Our Reference: SYD14/00894 (A7529223)
DP&E Ref: SSD 5093

M2 SITE WITHIN THE NORTH RYDE STATION URBAN ACTIVATION PRECINCT

Reference is made to your letter dated 5 August 2014, regarding the abovementioned Application which was referred to Roads and Maritime Services (Roads and Maritime) for comment in accordance with Section 87 and 138 of the *Roads Act, 1993*.

Job Title
North Ryde Station Precinct
M2 Site
State Significant
Development
Pedestrian and Cycle
Bridge

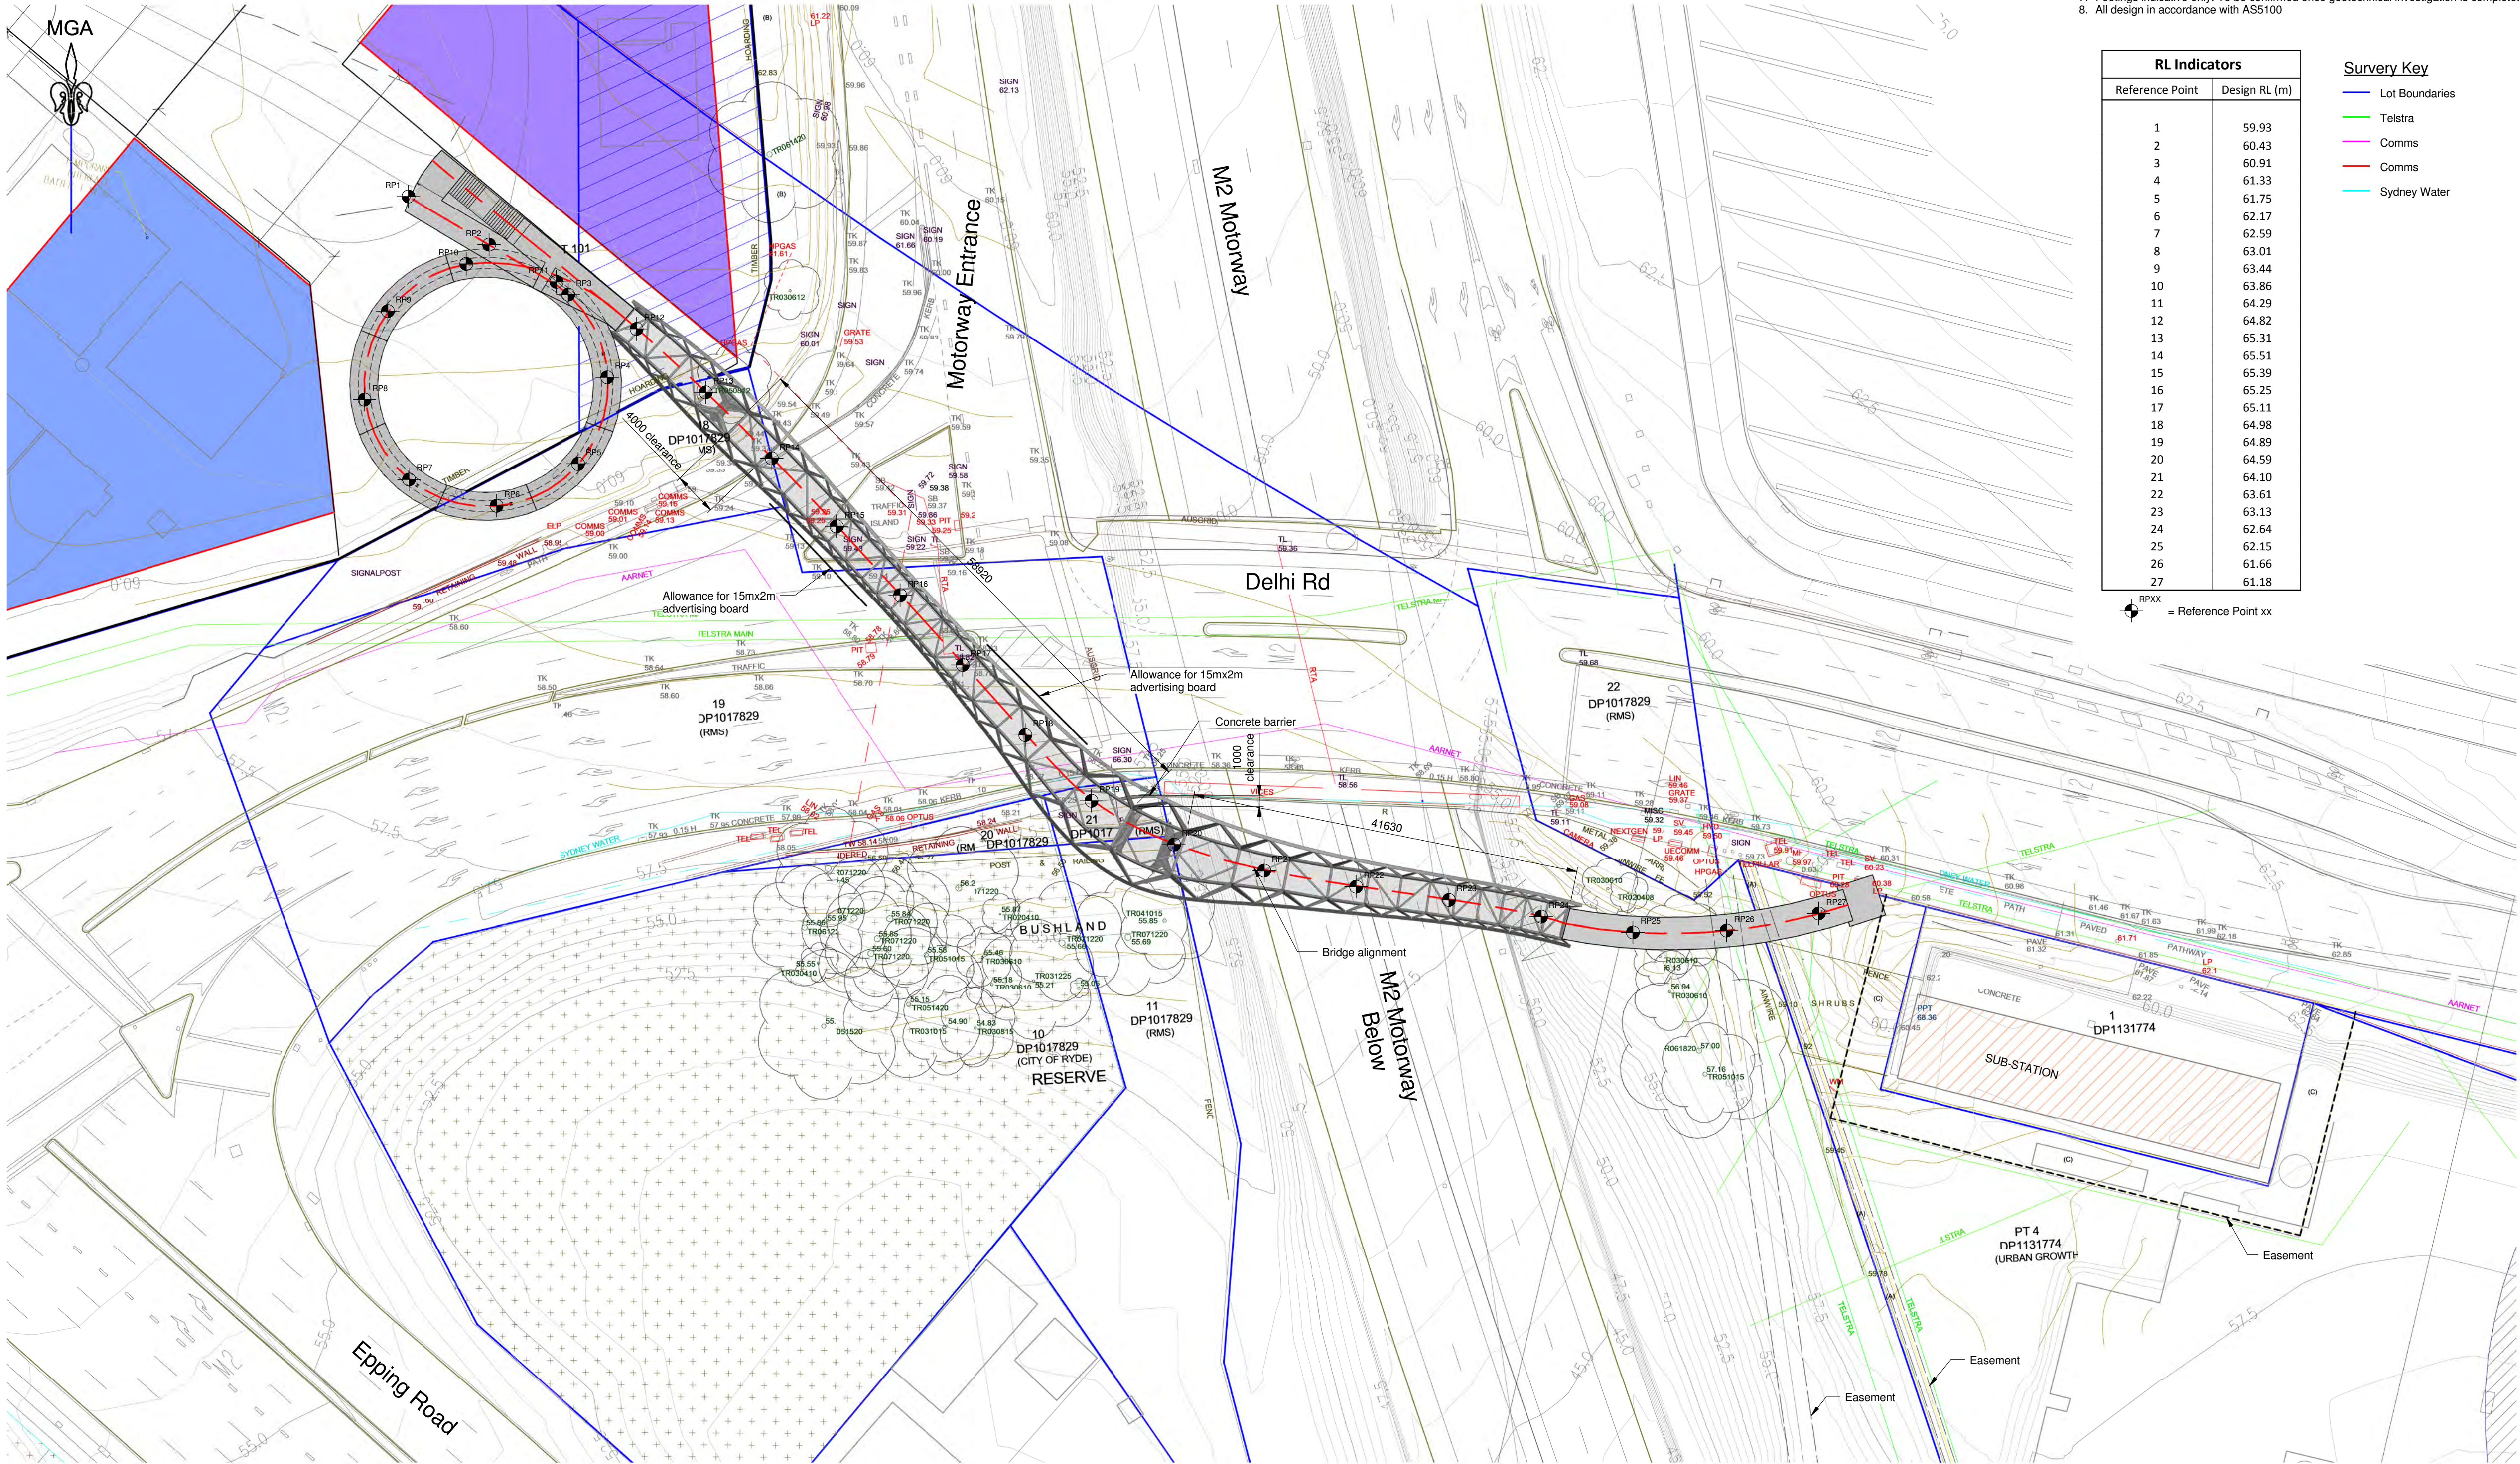
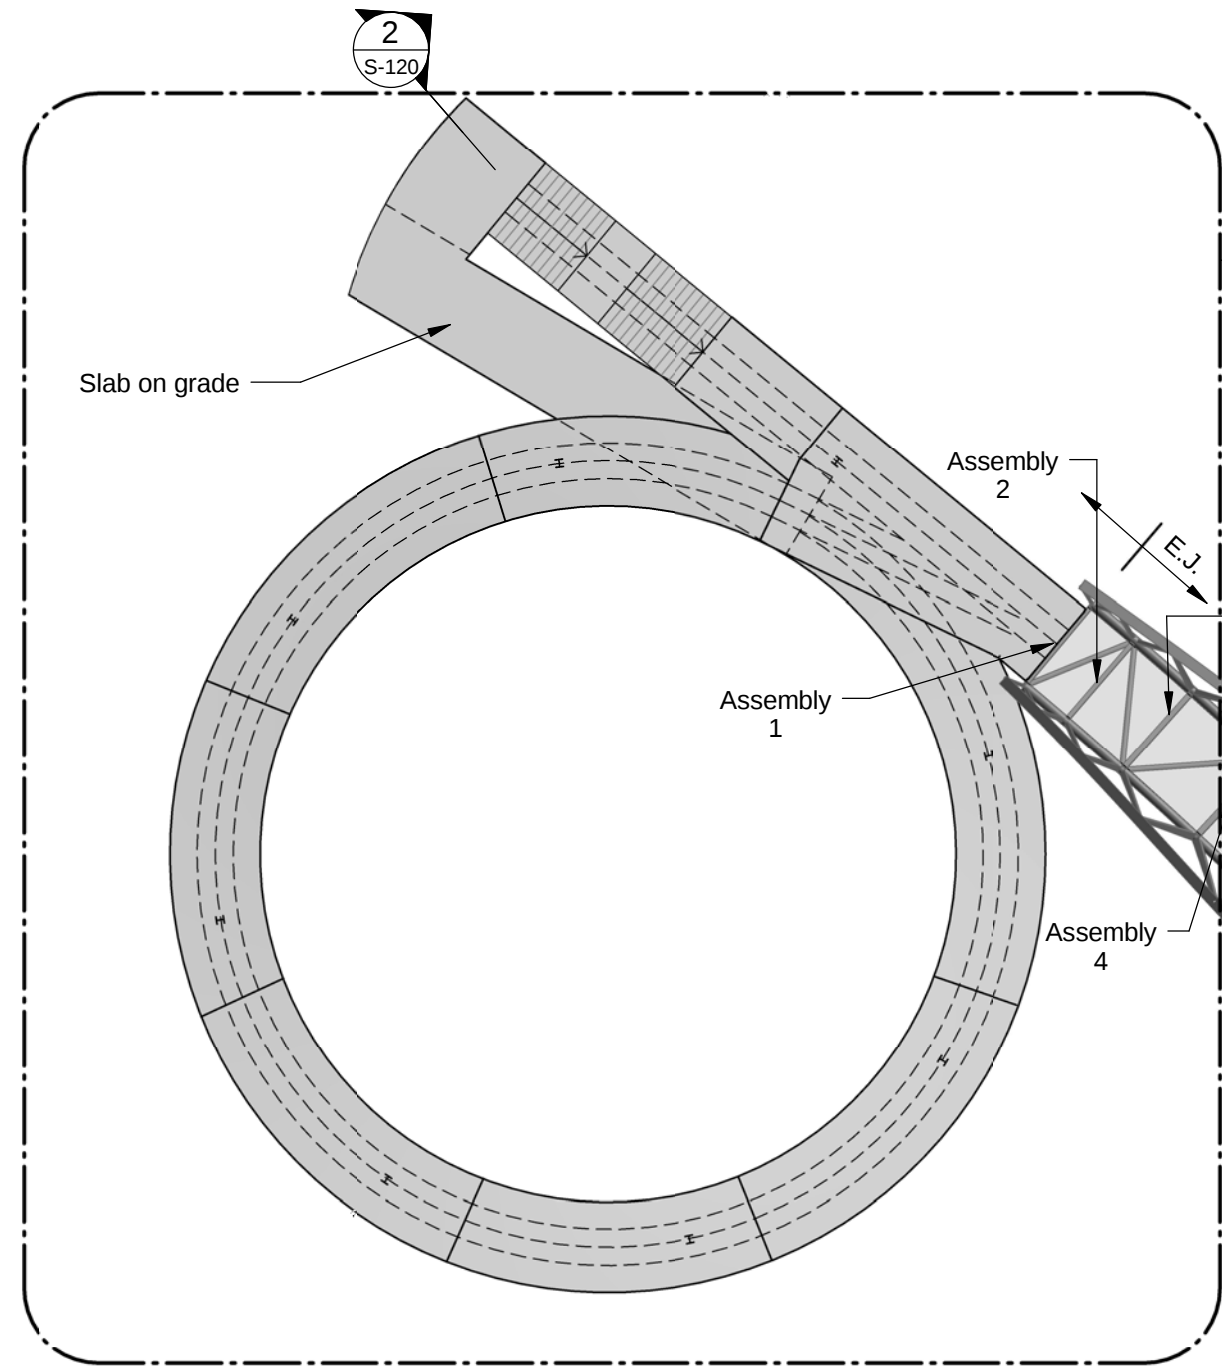
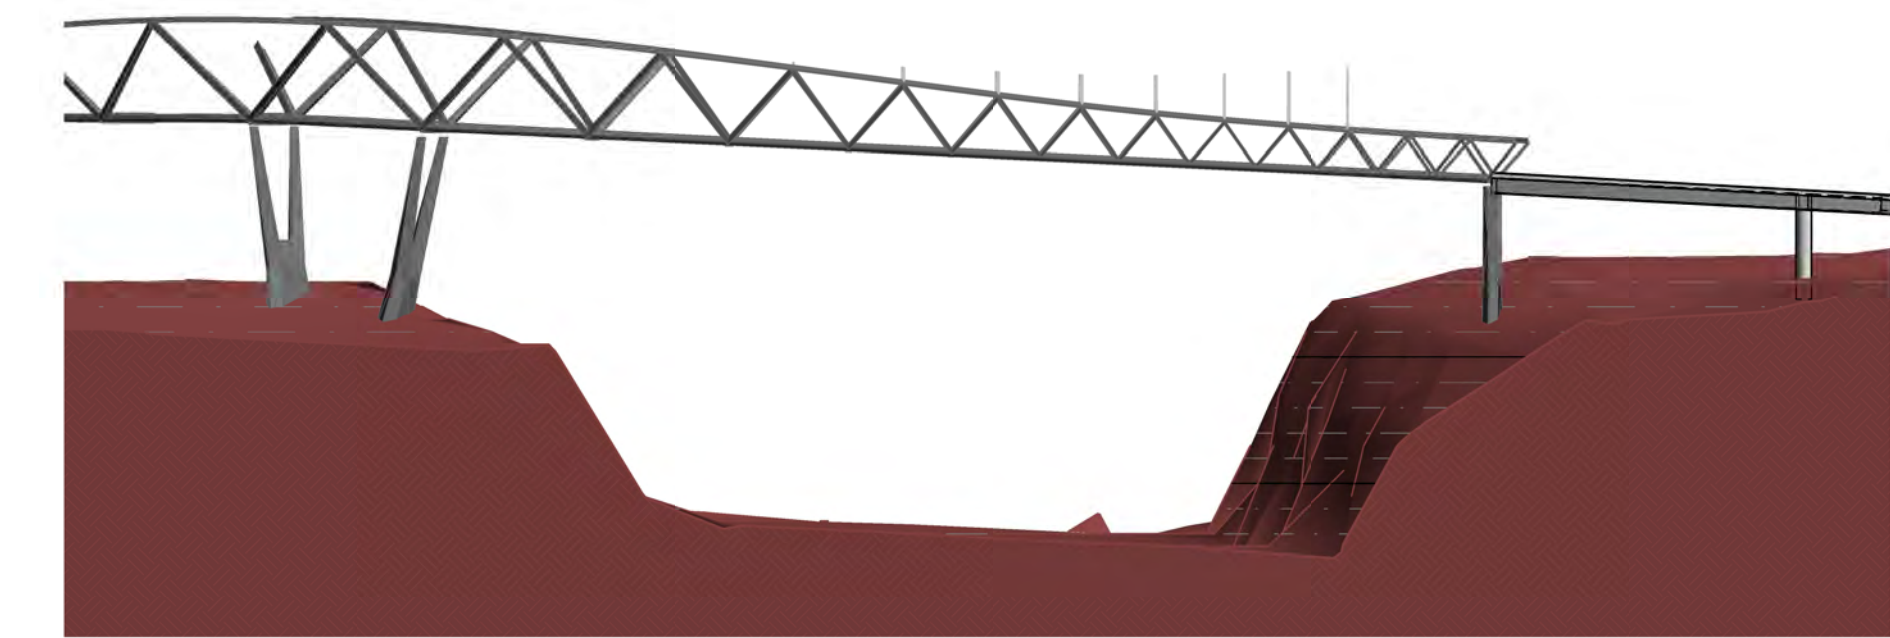
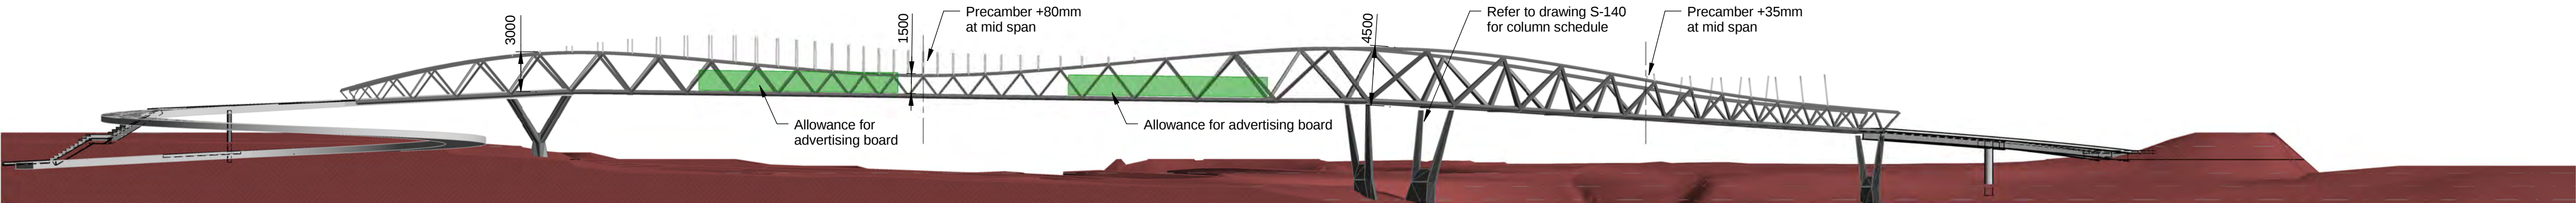
There are a few areas in the report in which it is stated the pedestrian bridge will be handed over to Council. Previous conversations with Roads and Maritime and UrbanGrowth have discussed the bridge would be in the ownership of Roads and Maritime. The applicant should advise Roads and Maritime if Council wishes to own this asset.

- The bridge shall be designed and constructed in accordance with relevant Roads and Maritime standards. The bridge shall have a minimum 100 year design life.
- The developer shall prepare and implement an appropriate community engagement plan for the construction of the bridge to the satisfaction of Roads and Maritime.
- The ownership and maintenance arrangements for the bridge shall be to the satisfaction of Roads and Maritime.
- Road, bridge and traffic control facility works associated with the bridge shall be undertaken by a pre-qualified contractor. A copy of pre-qualified contractors can be found on Roads and Maritime website at:

The pedestrian and cycle bridge shall be designed and constructed in accordance with Austroads Guide to Road Design in association with relevant Roads and Maritime supplements (available on www.rms.nsw.gov.au). The certified copies of the civil design plans shall be submitted to Roads and Maritime for consideration and approval prior to the release of a subdivision certificate (for creation of super lots 201-208) by the appointed Private Certifier or Council and commencement of road works.
